**CITY OF PORTLAND, MAINE
DEVELOPMENT REVIEW APPLICATION
PLANNING DEPARTMENT PROCESSING FORM
DRC Copy**

2003-0212

300 Diamond Ave.

- 1 IF BLASTING IS TO OCCUR, A BLASTING PERMIT MUST BE OBTAINED FROM THE CITY OF PORTLAND FIRE PREVENTION DEPARTMENT.
- 2 Two (2) City of Portland approved species and size trees must be planted on your street frontage prior to issuance of a Certificate of Occupancy.
- 3 Your new street address is now #300 DIAMOND AVENUE, the number must be displayed on the street frontage of your house prior to issuance of a Certificate of Occupancy.
- 4 The Development Review Coordinator reserves the right to require additional lot grading or other drainage improvements as necessary due to field conditions.

SHEET TITLE:
SITE PLAN

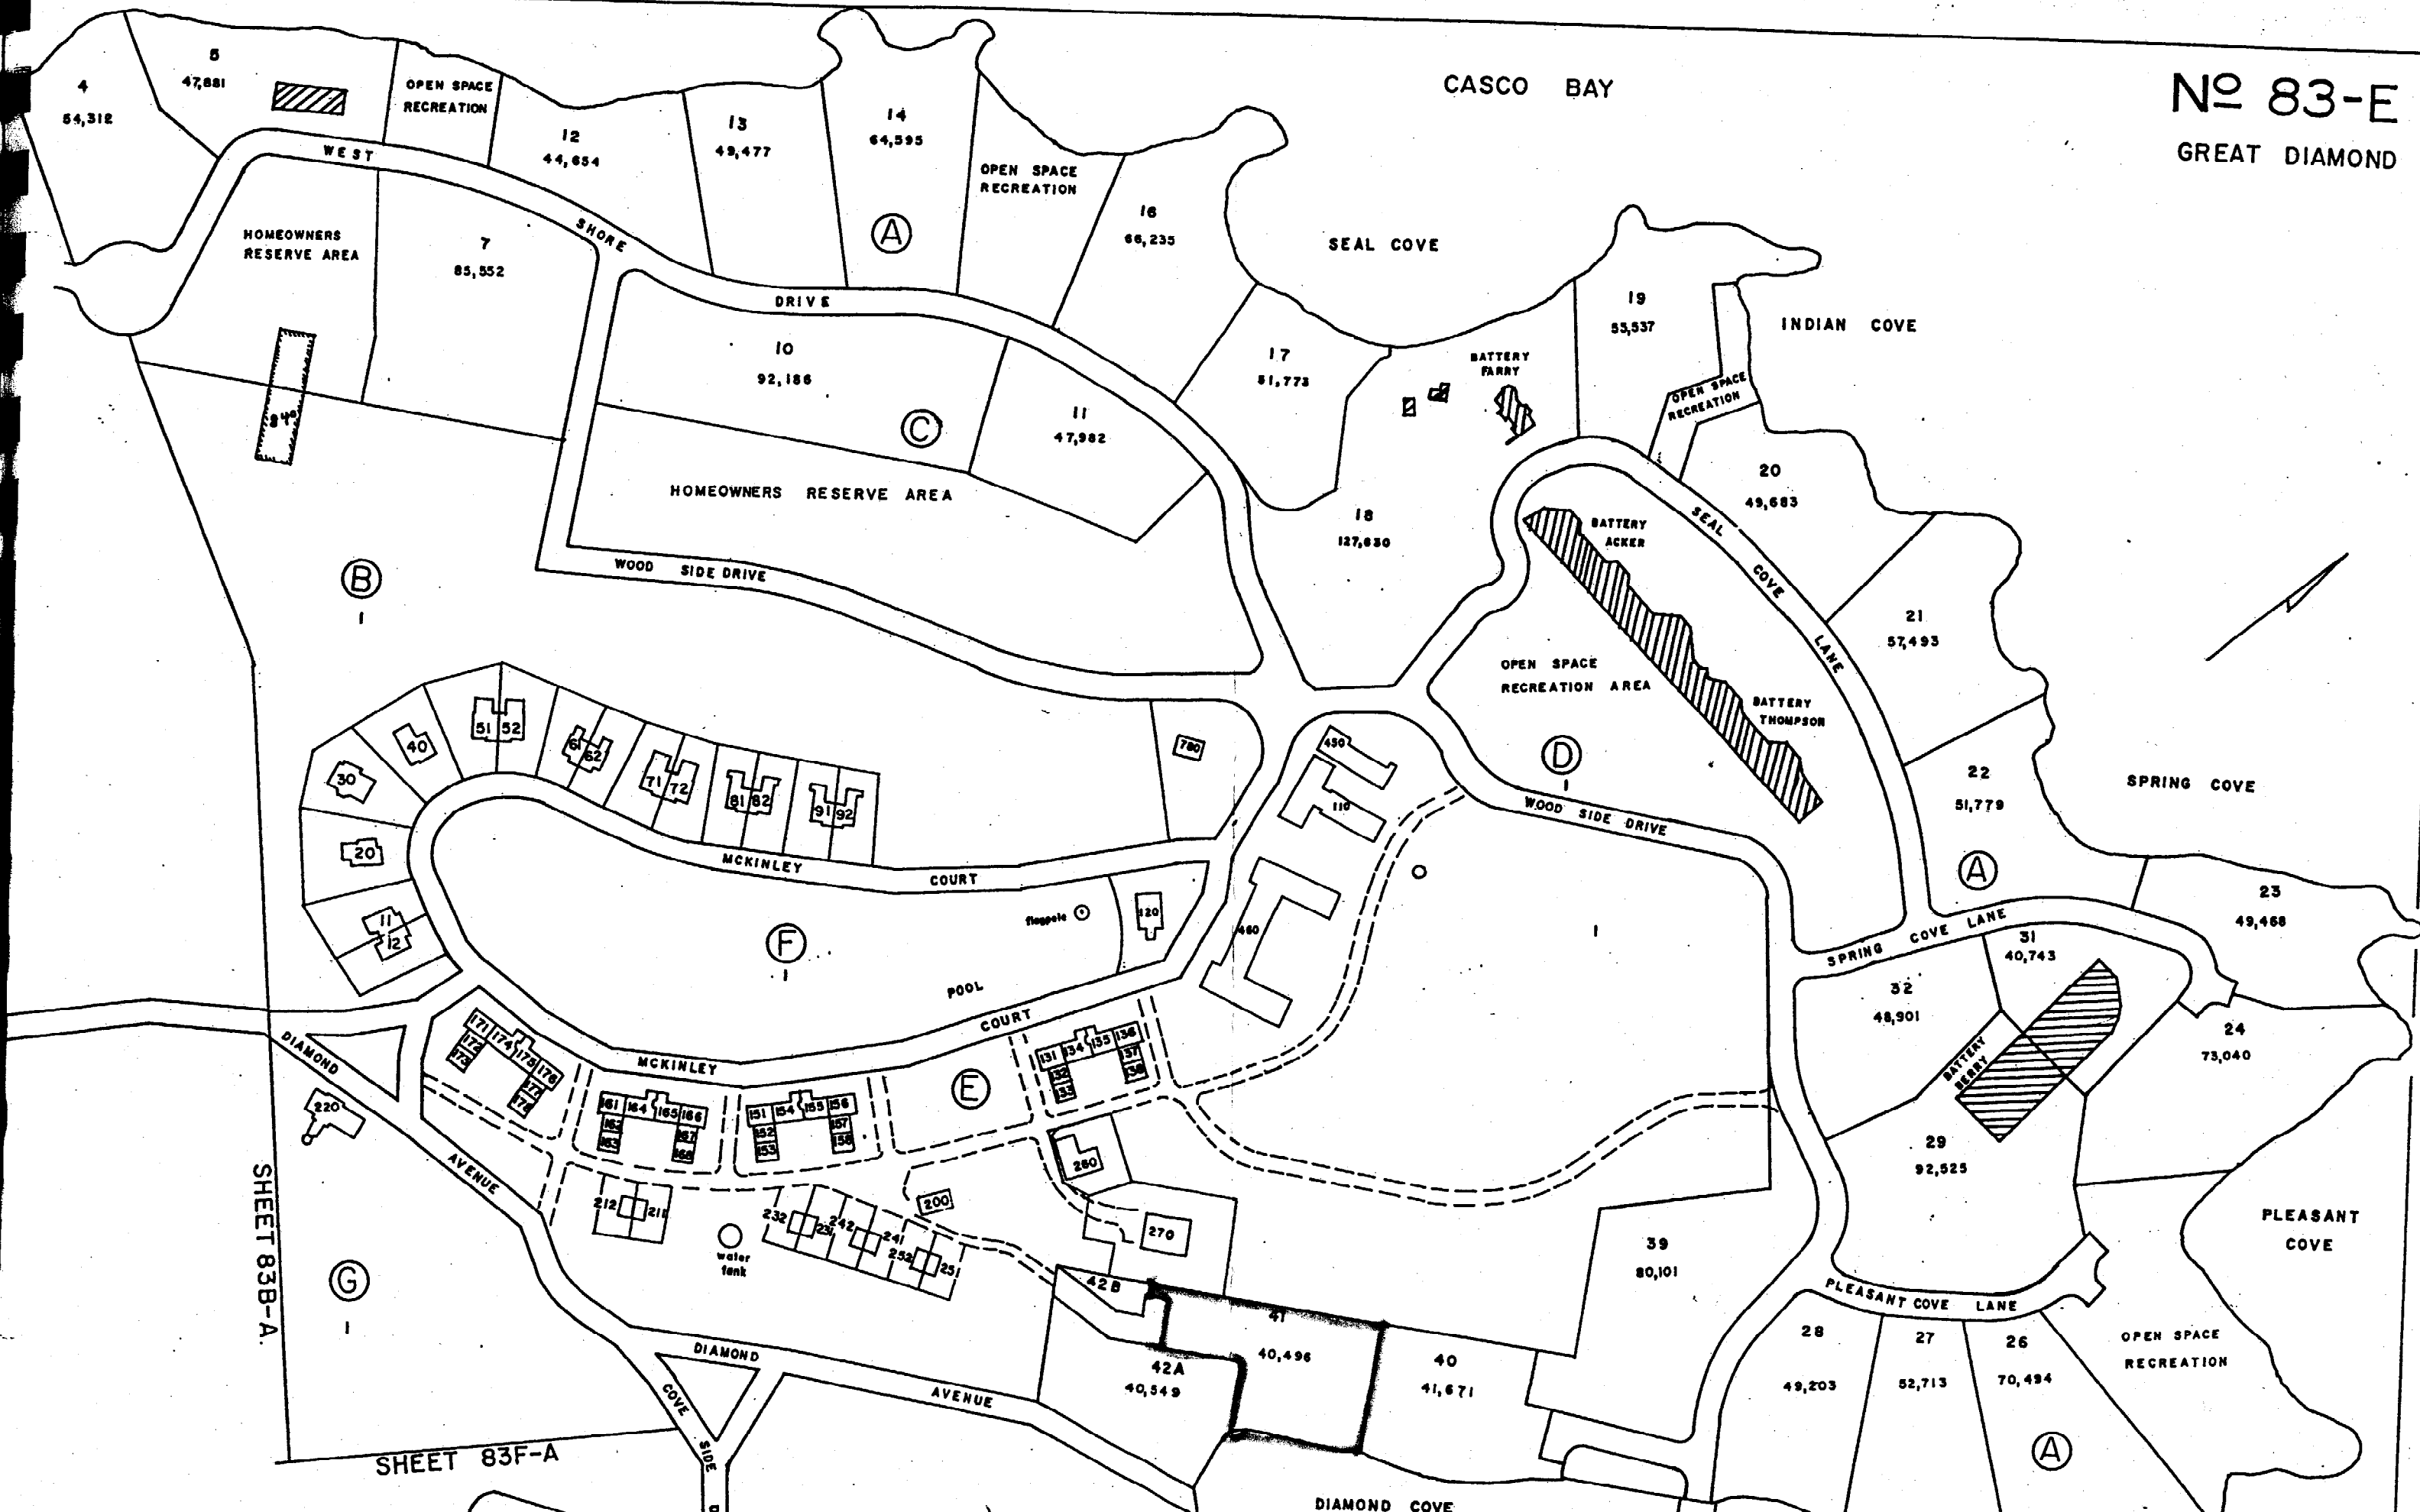
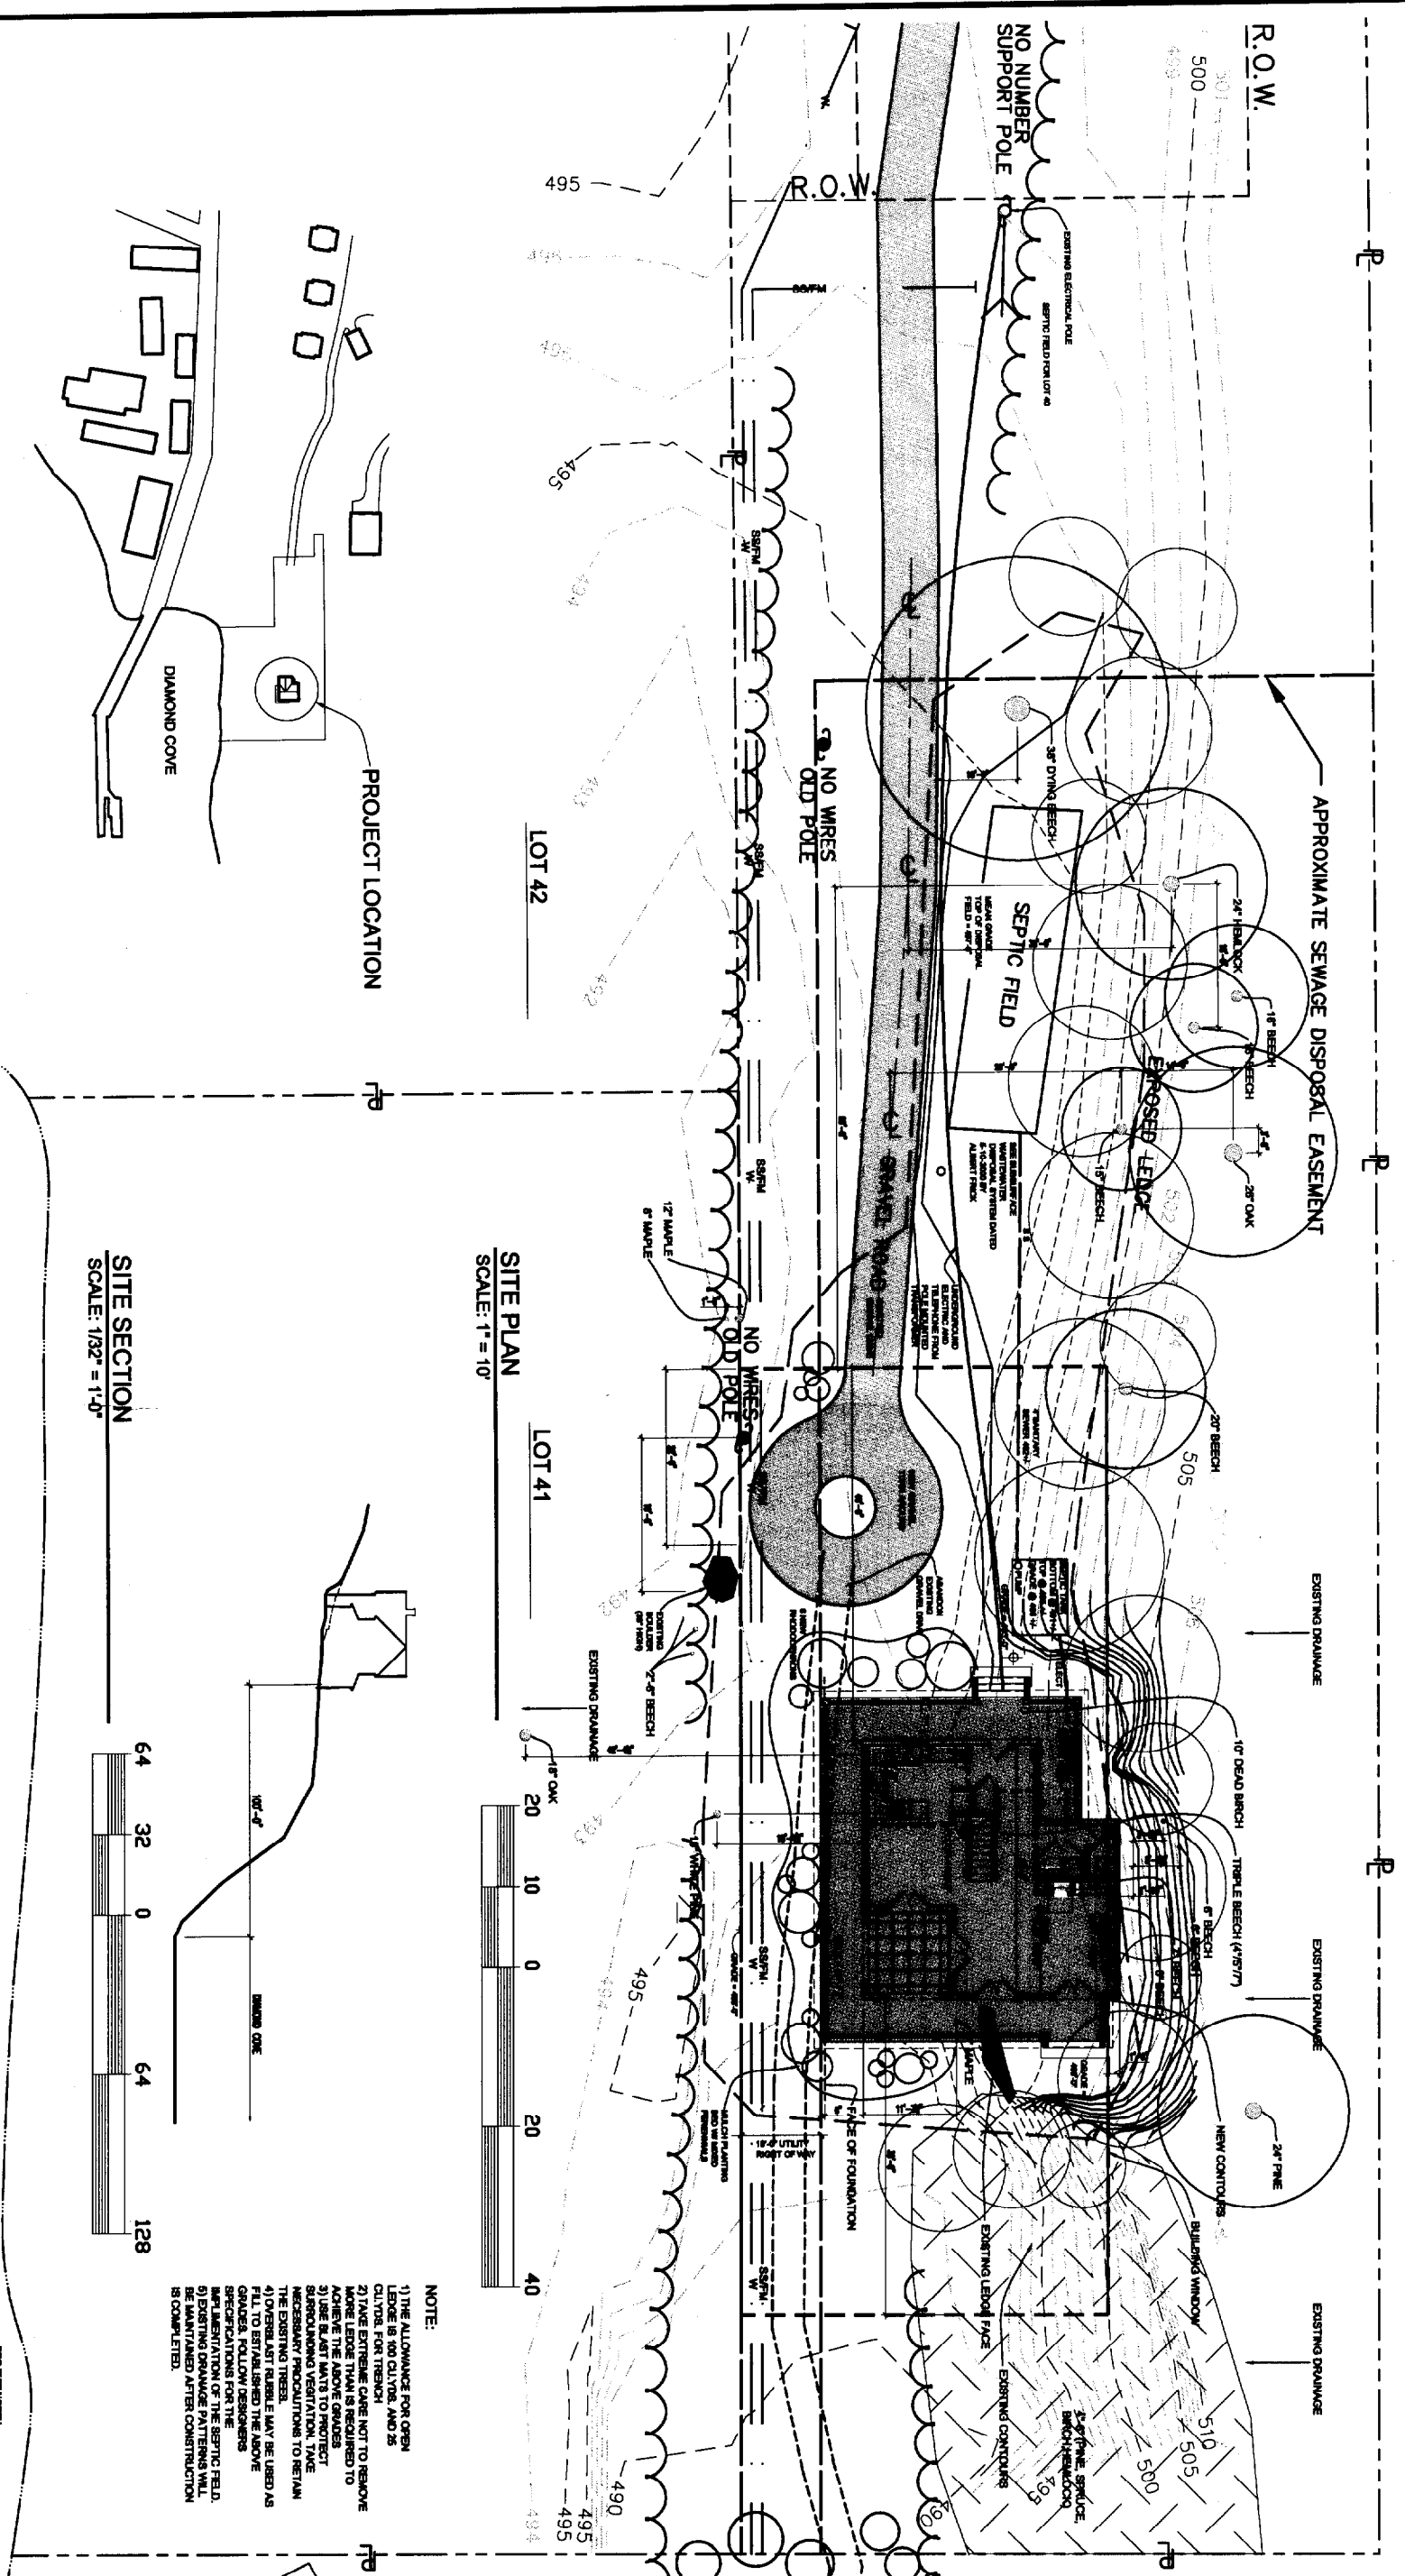
Where is this? Which lot? R5? X
Assess; road existing? X
Planting notes? Remove... X
Fill over utilities
Where are drainage pp? X
Restrictive lot? X
